## SICEEP, Residential Building W1 (Student Accommodation) (SSDA12) – Response to Department of Planning and Environment Submission

## SICEEP, Residential Building W1 (Student Accommodation) (SSDA12) – Response to City of Sydney Council Submission

1 WEST ELEVATION 1:200

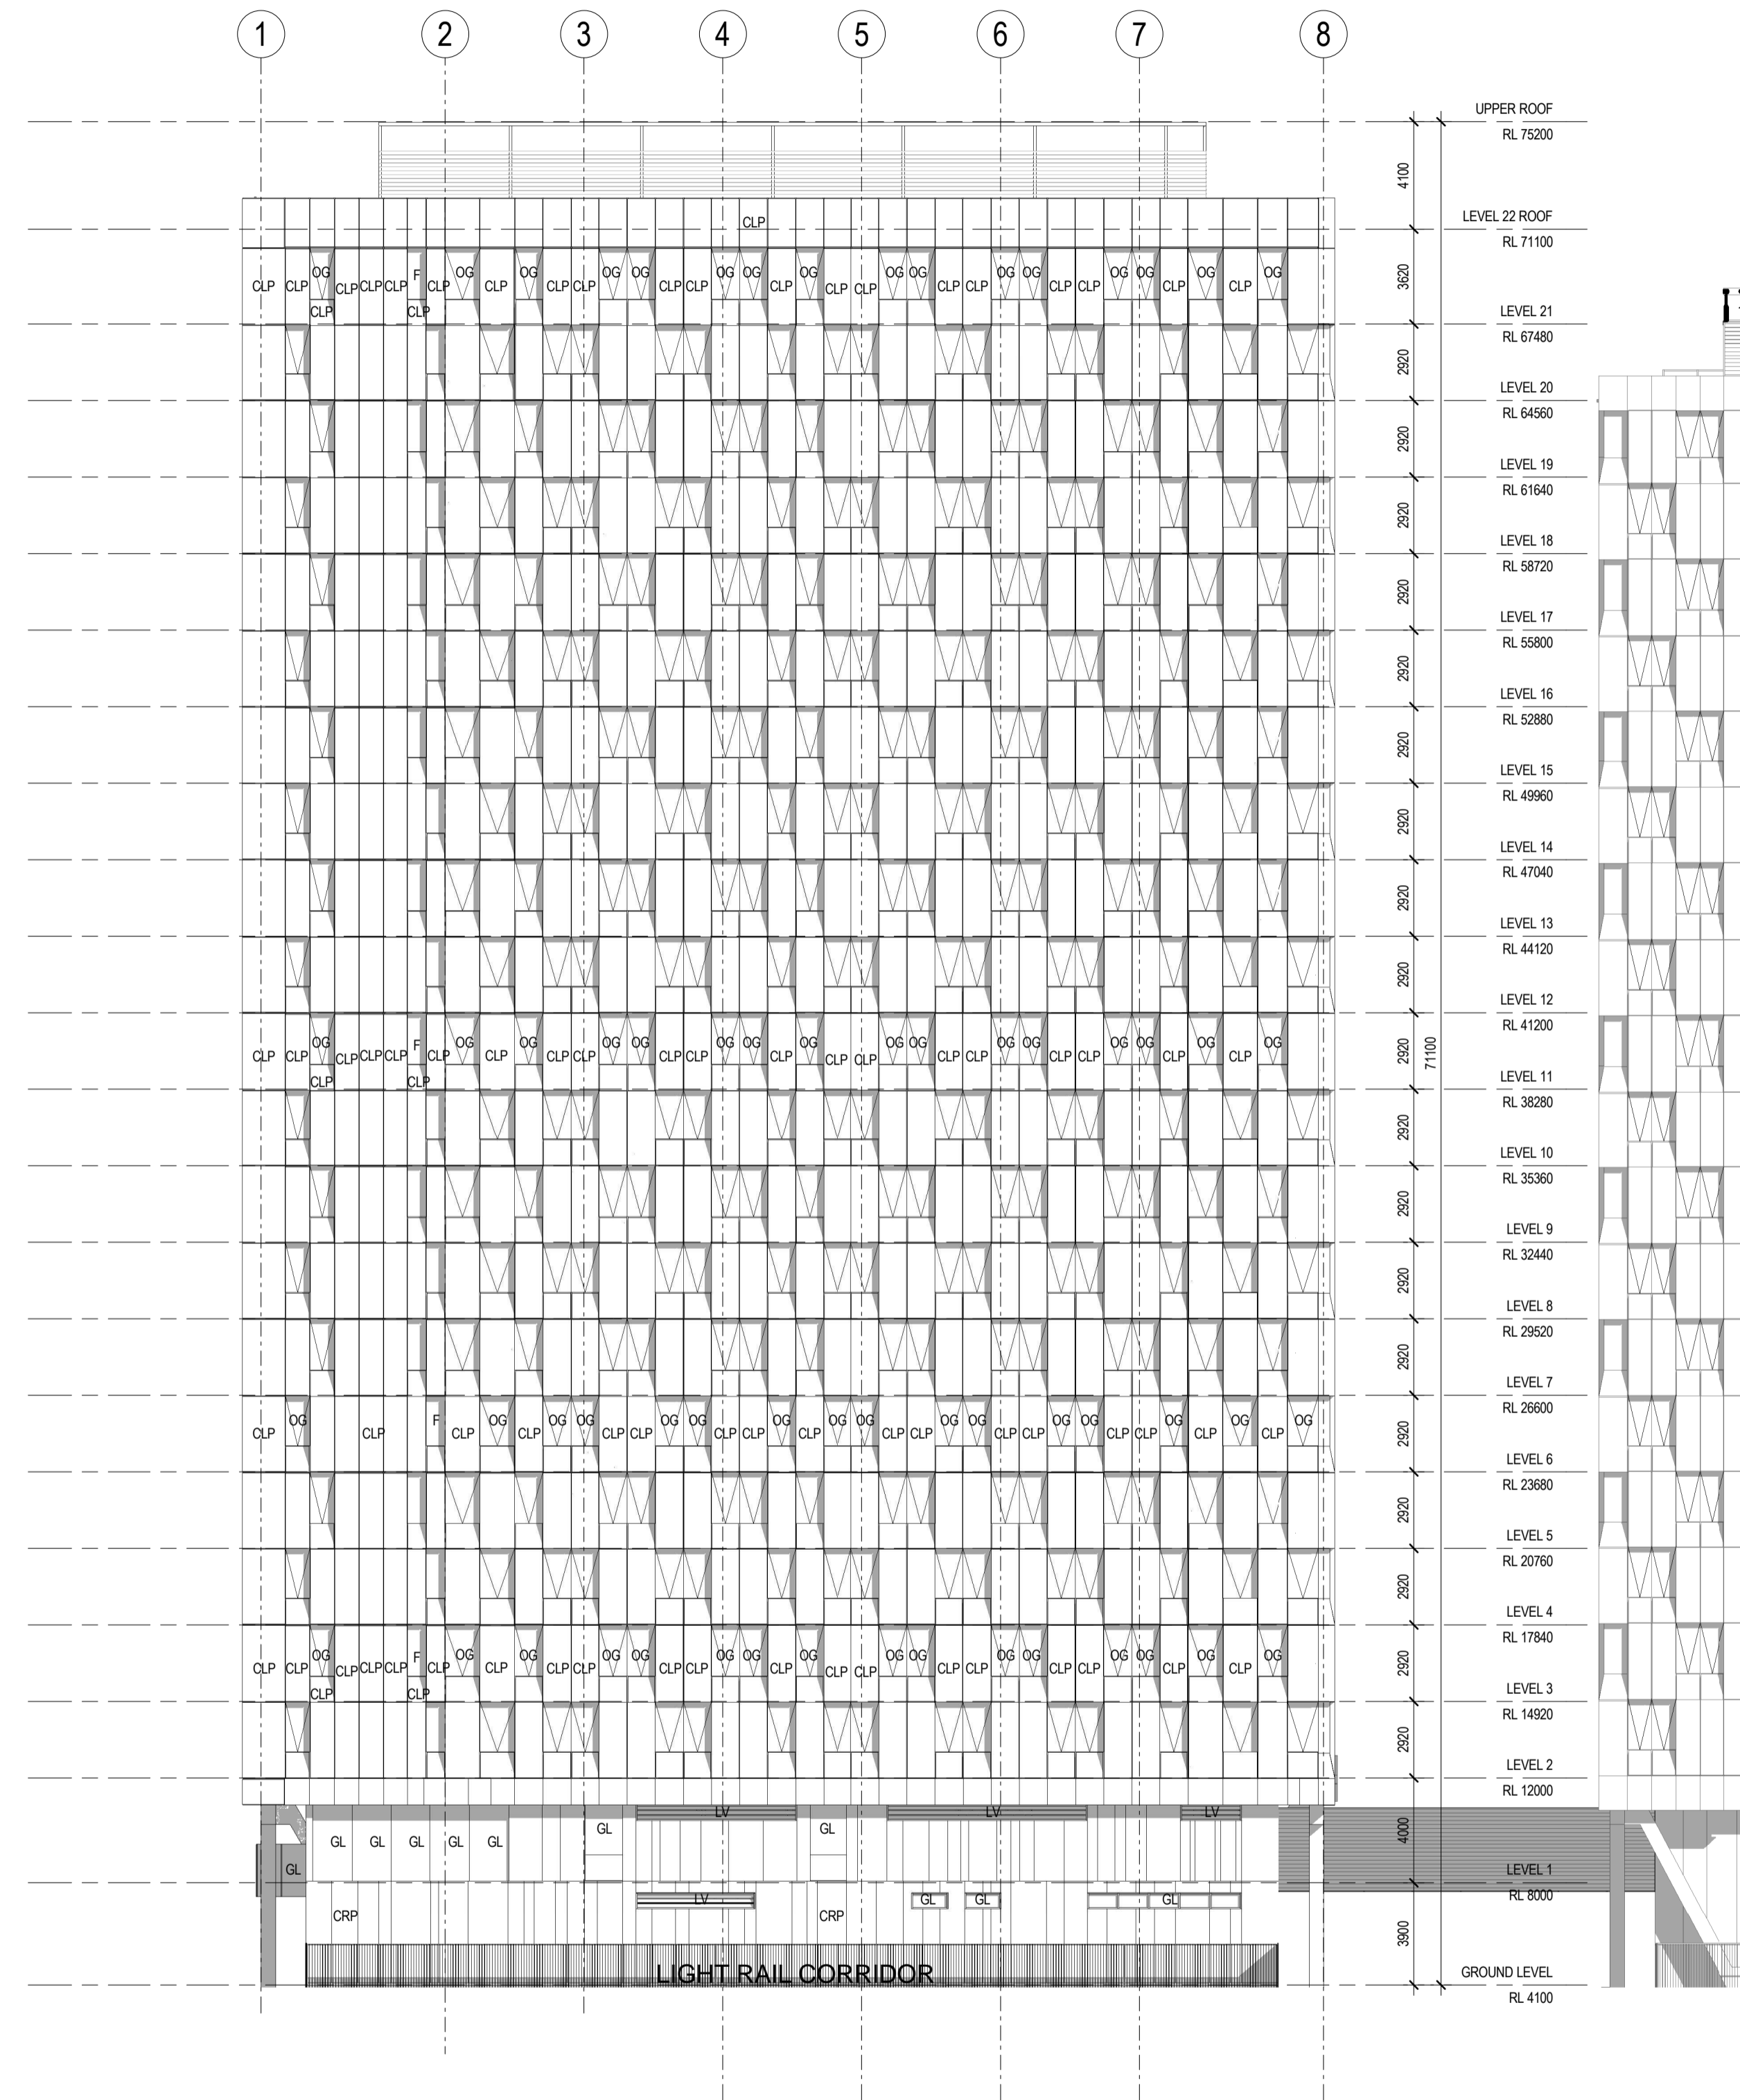
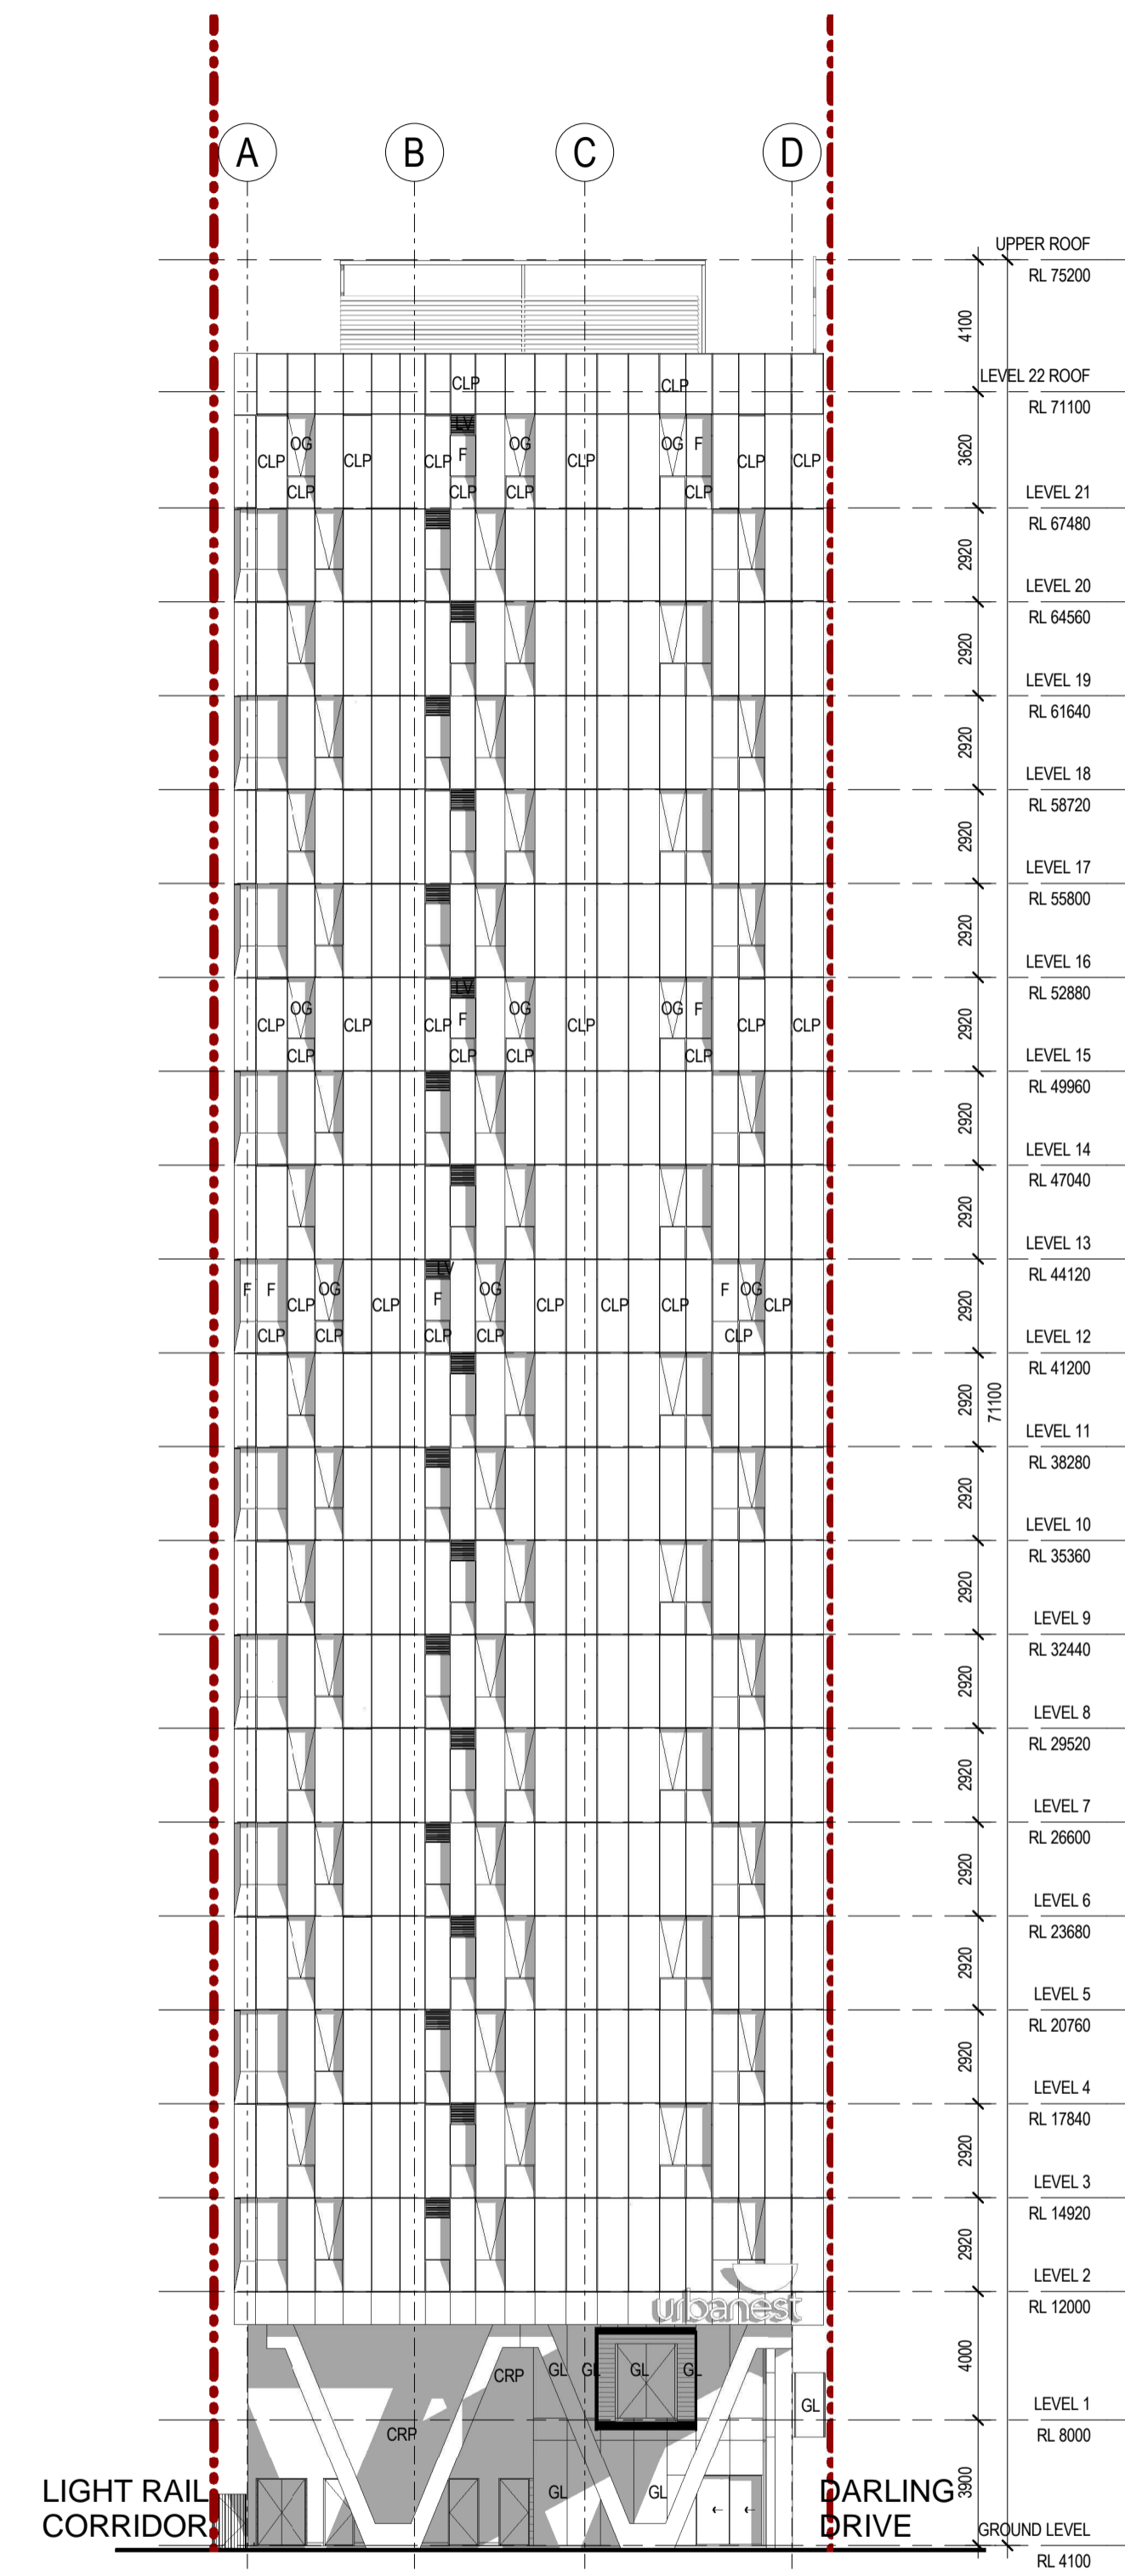
<b>Building Design</b>	
<p><b>Western façade</b></p> <p>It is unclear from the proposal how the facade which fronts the heavy rail corridor is proposed to be accessed for cleaning and maintenance. Further clarity is required to confirm that the use of the building maintenance unit on the south elevation will not impact on the operation of the heavy rail corridor.</p>	<p>Refer to DA2103, as amended.</p> <p>The façade of Building W1 has been designed with a relationship to Building W2, with variation provided to the north eastern addressing the open corner site. Similarly to Building W2, all facades are accessed by a Building Maintenance Unit (BMU) located on the roof (BMU added to the Roof Plan for clarity).</p>
<p><b>V columns</b></p> <p>The street wall façade concept of the 'V' columns at the lowest two levels is supported as an architectural concept, particularly as it extends from approved Building W2 to provide a consistent façade treatment along Darling Drive, reflecting the consistency of building use between the two buildings. However, along the north eastern corner of W1 an external balcony has been introduced at level 1 which effectively cuts the 'V' columns in half and reduces the strength of the concept. The City would support a smaller deck which does not extend past the internal line of the 'V' columns.</p>	<p>The balcony to Level 1 serves the dining facility and provides an outdoor space for students to use for dining and recreation. This element is designed as a long horizontal element to transition from the tall vertical expression of the building to the ground plane, and purposely intersects with the 'V' columns.</p> <p>This element will be read as a light linear floating platform suspended by the 'V' column truss, rather than smaller discontinuous Juliet balconies. This overall scale of the building and the streetscape is considered to be more appropriate.</p>
